Water Resources Report – Deim Subdivision at Sundance Ranch

**Deim Subdivision
Letter of Intent**

February 5, 2025

# DEIM SUBDIVISION

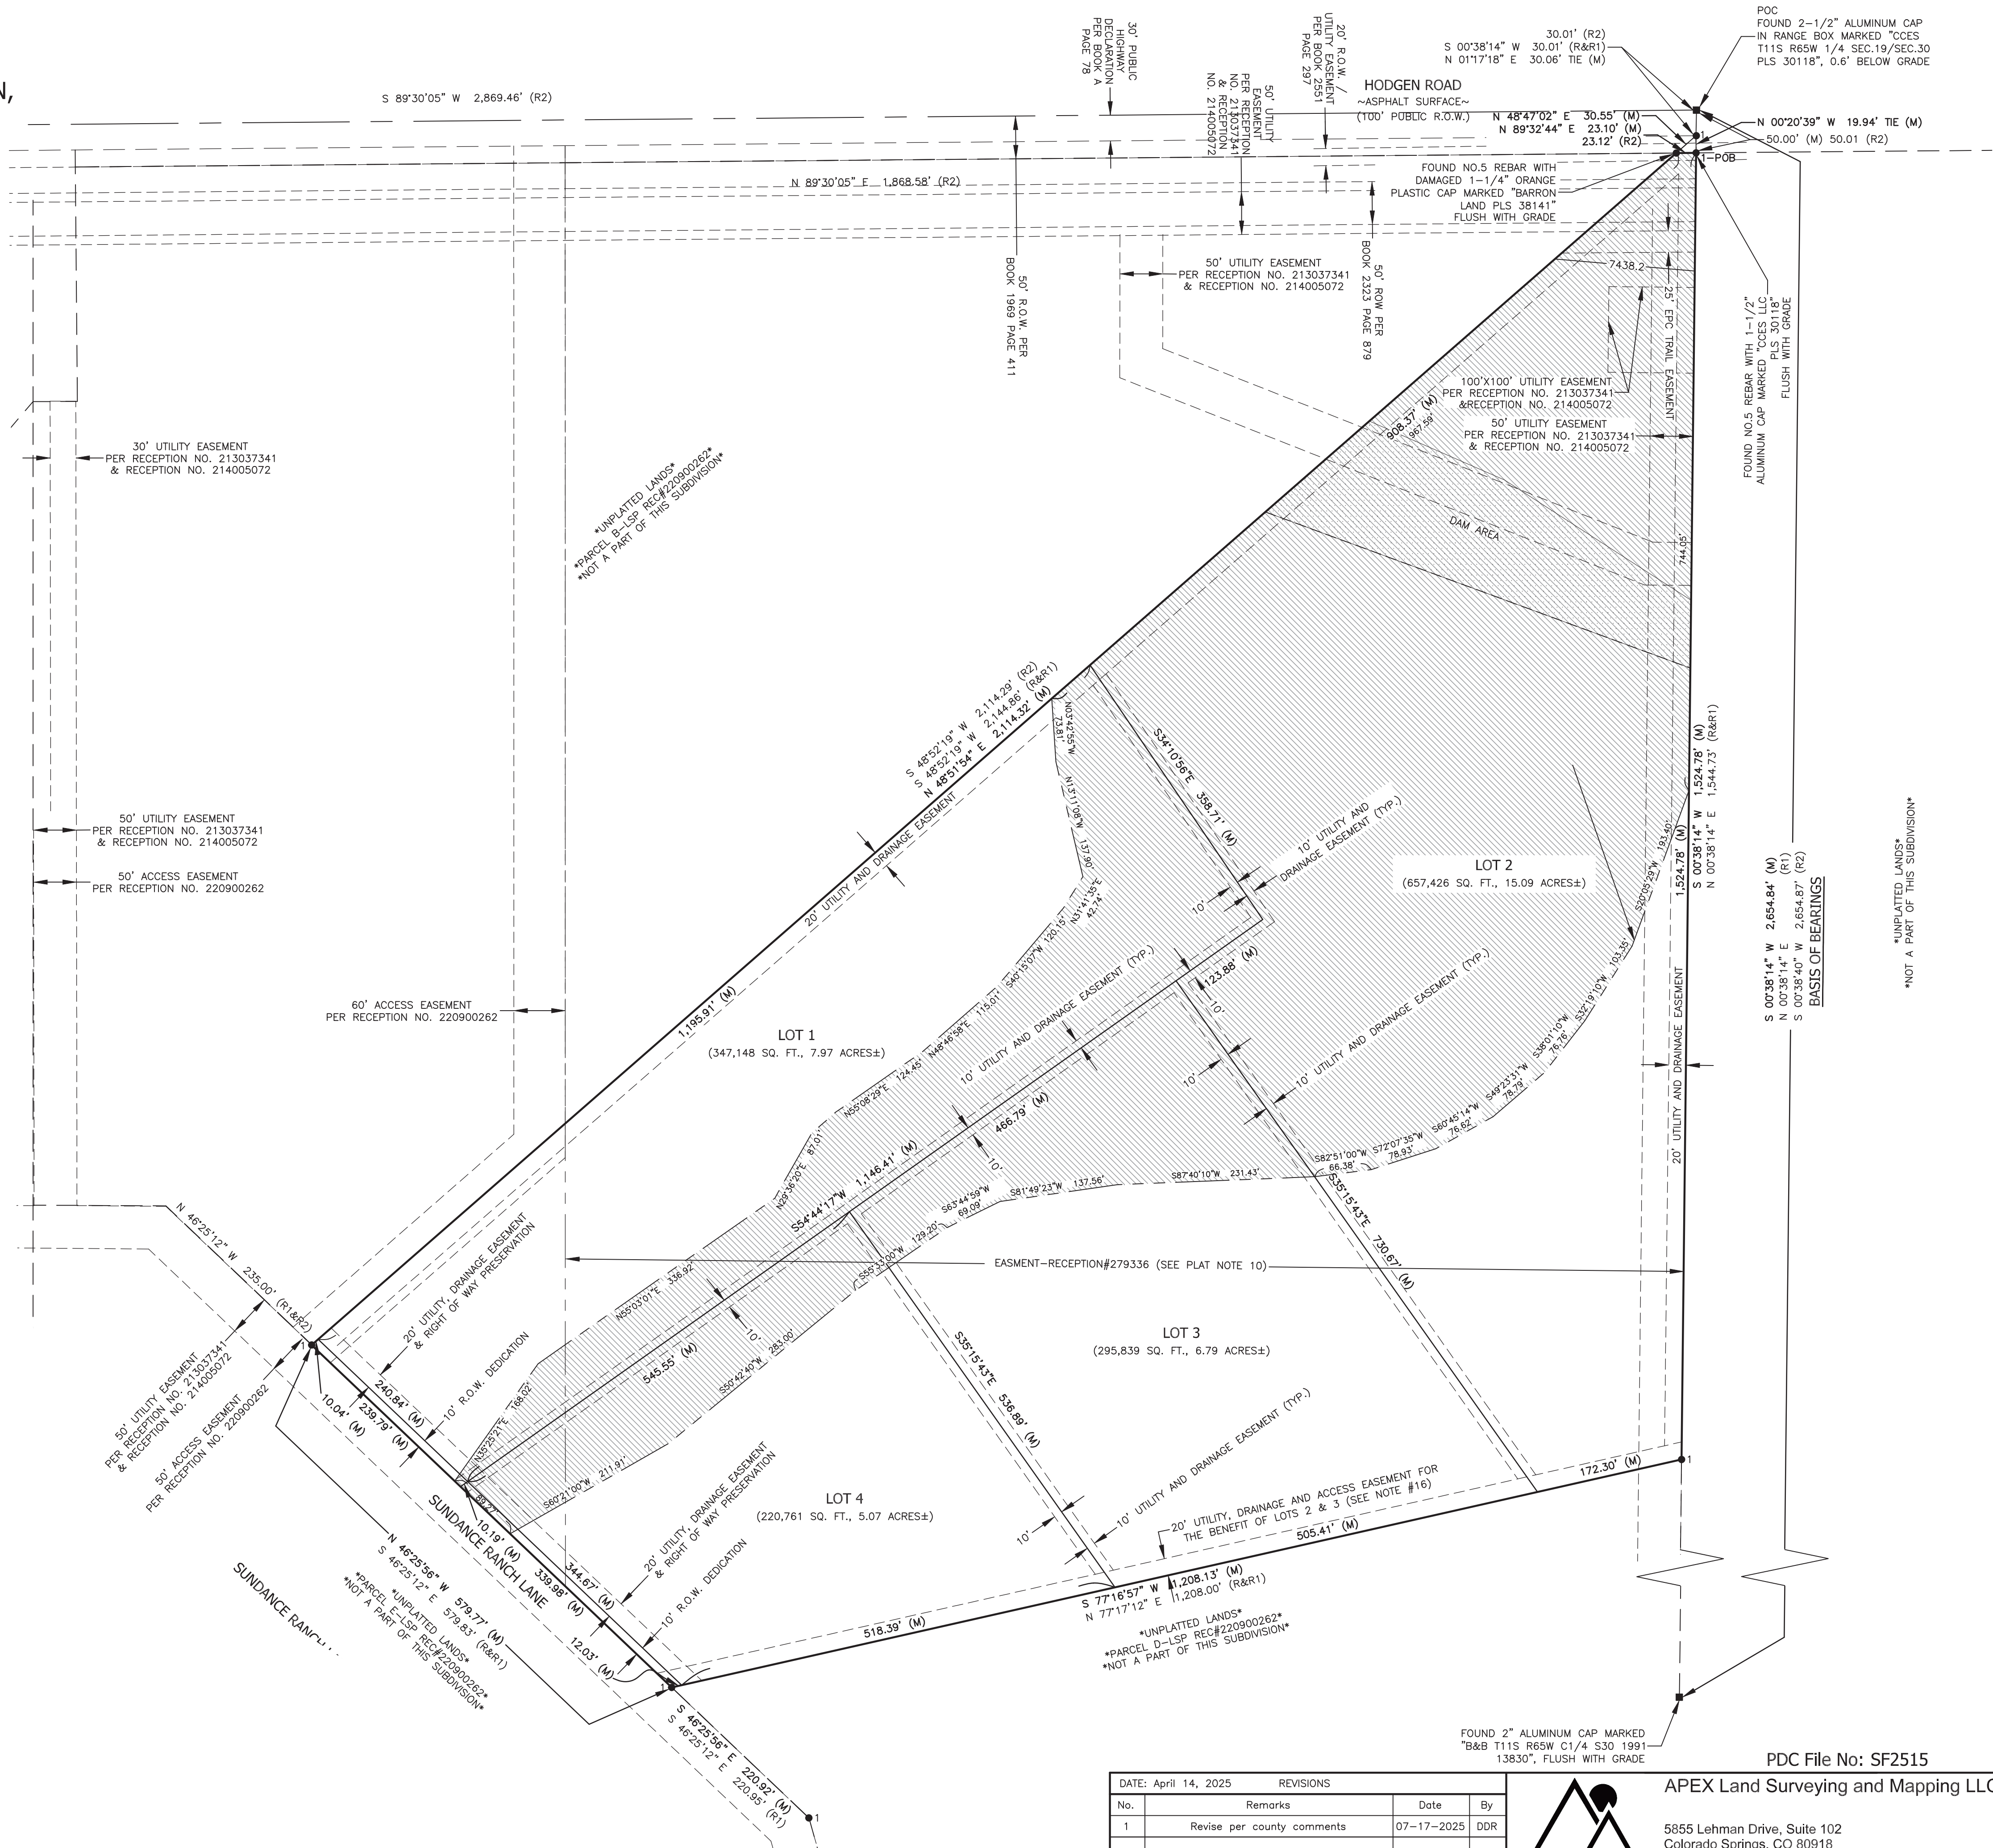
Please include access easements
for lots 2 and 3

not found; discuss with Staff

The plat depicts a 60-foot right-of-way being dedicated to El Paso County at the request of the Department of Public Works. However, El Paso County will not accept this right-of-way for ownership and maintenance until the adjacent property owners have also dedicated right-of-way to El Paso County from Hodgen Road to the subject property and the roadway is brought up to County standards.

frontage also? ADDED

THE
SURVEYOR
MISSED
THIS IN
THE INITIAL
DRAFT, IT
HAS BEEN
ADDED

DEIM SUBDIVISION
EXISTING CULVERT WAIVER EXHIBIT

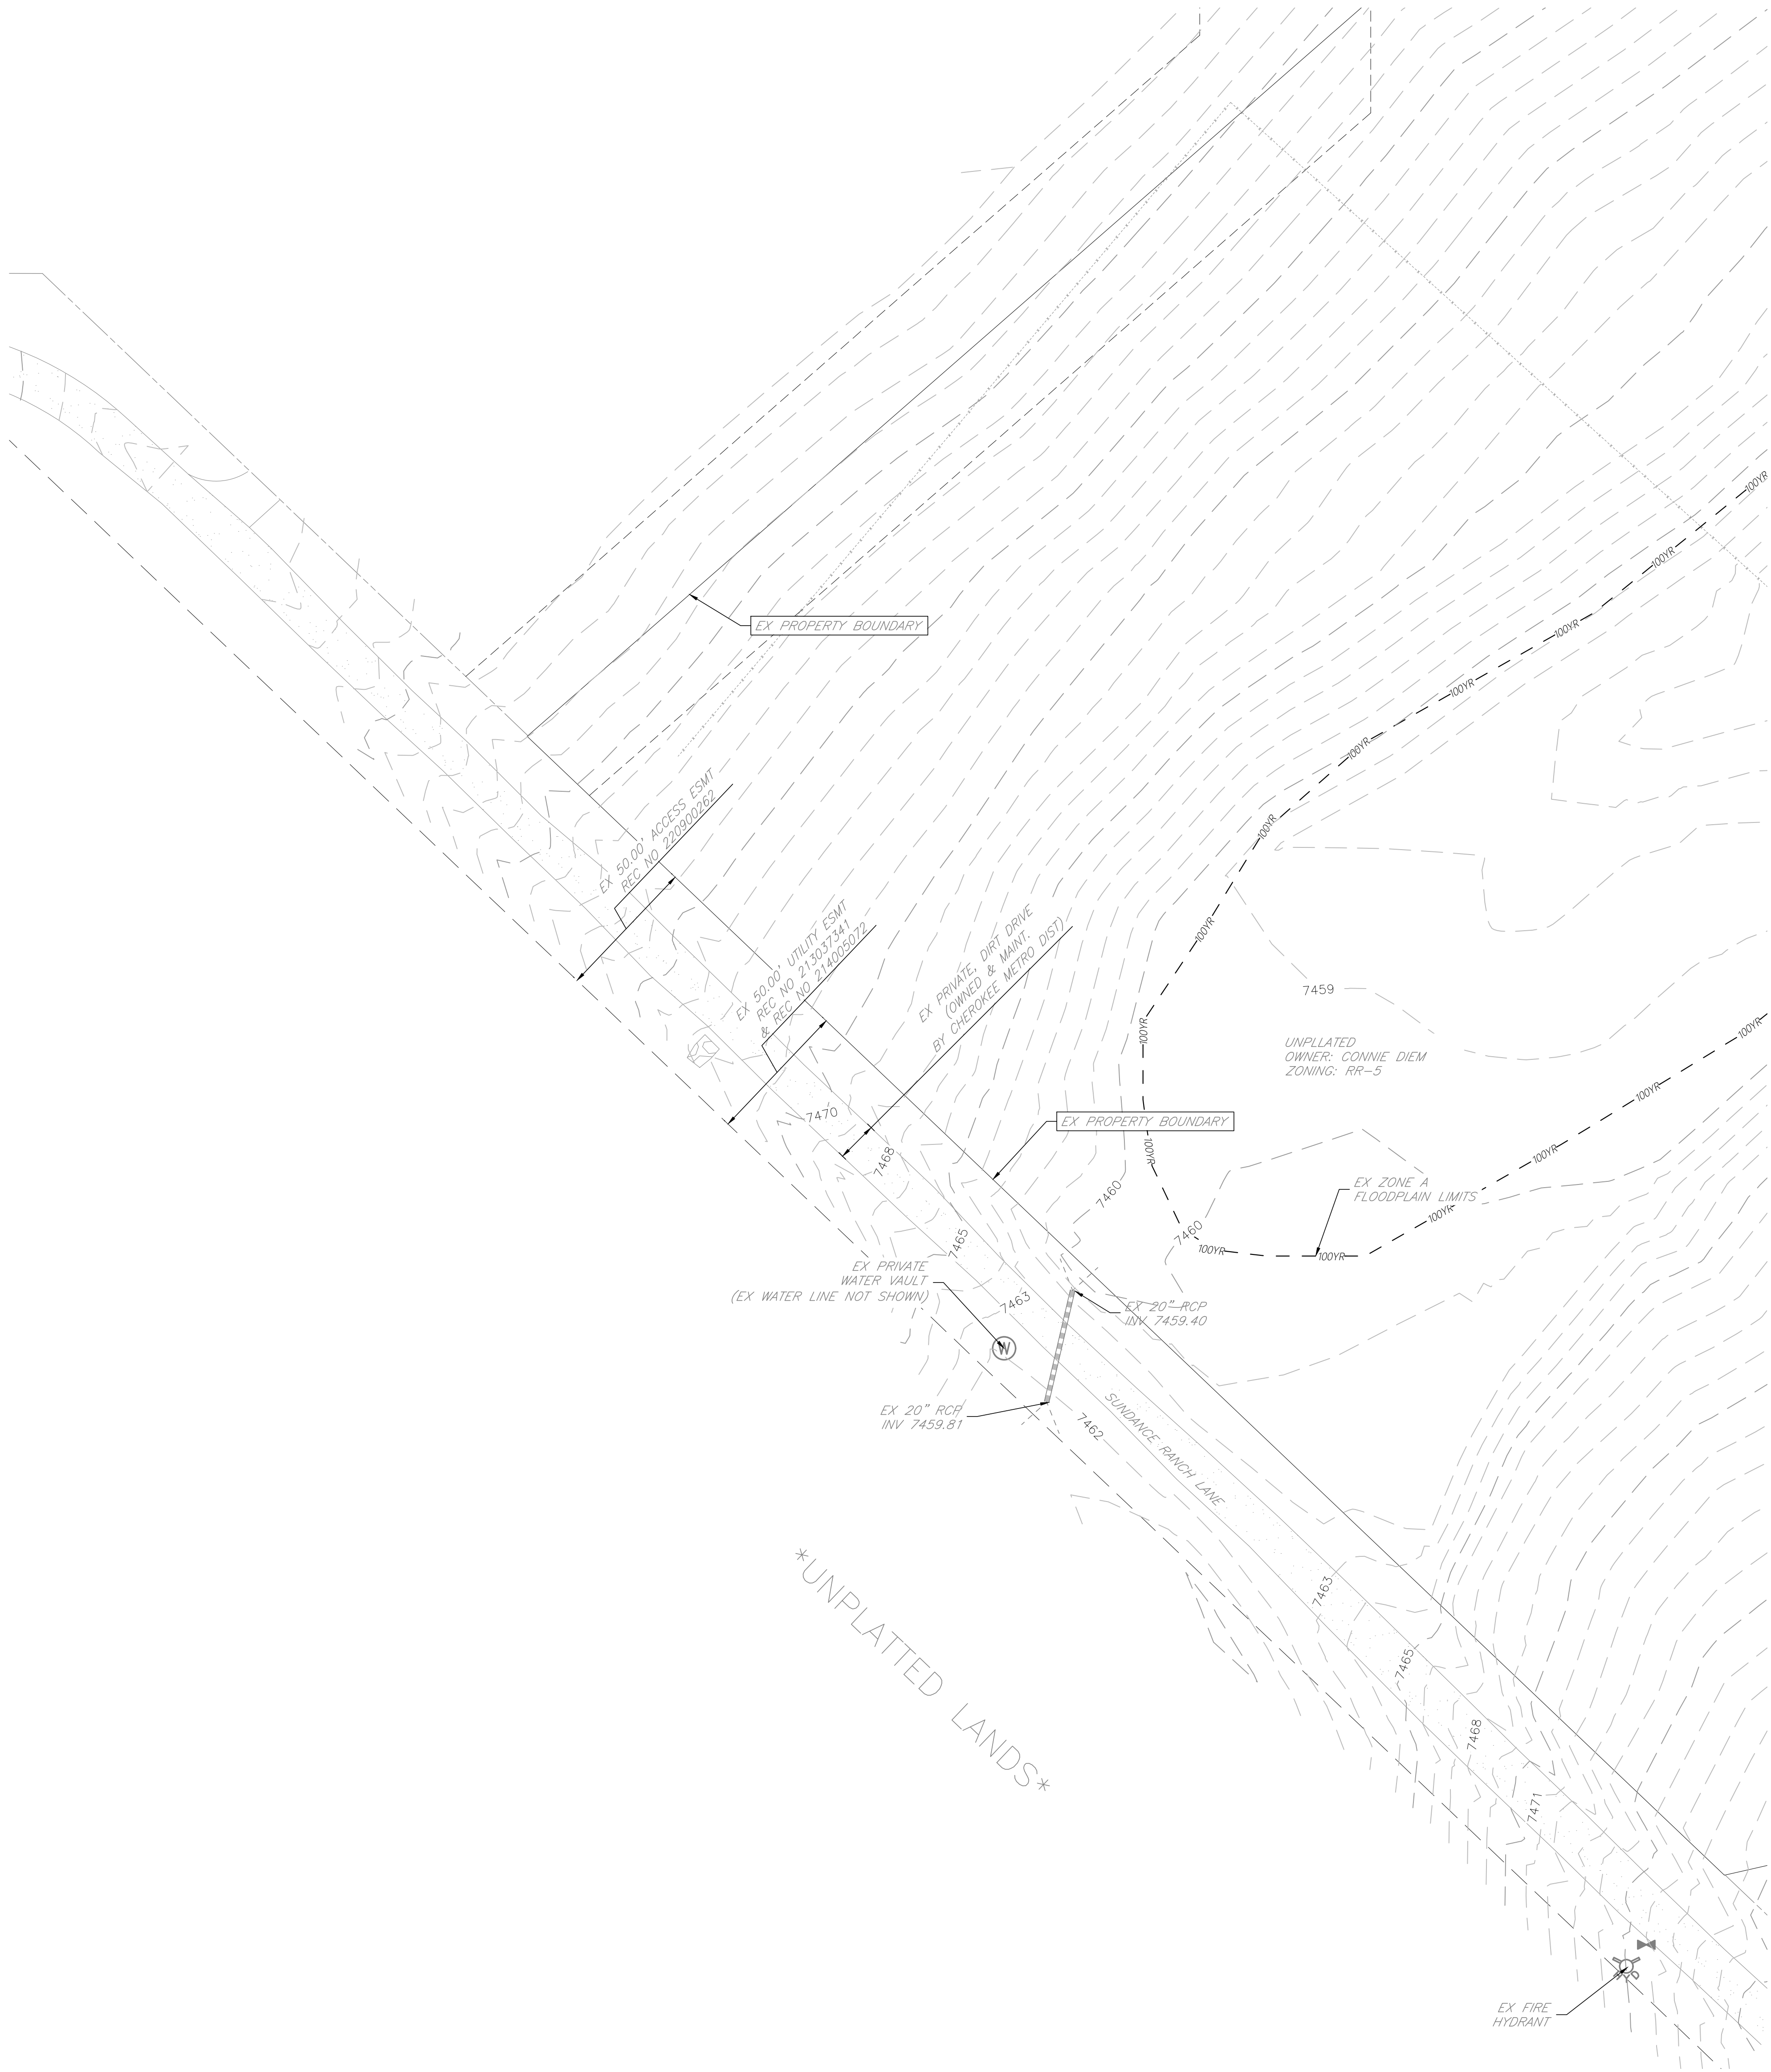
THE SURVEYOR HAS VERIFIED THAT GRADES DO NOT EXCEED 8%
portions of the road fronting and providing access to the property appear to be steeper than 8% - address all deviations including length of road, lack (or provision) of cul-de-sac, and minimum centerline radius. Also address drainage deviations such as roadway overtopping/culvert design. Provide deviation requests as needed.
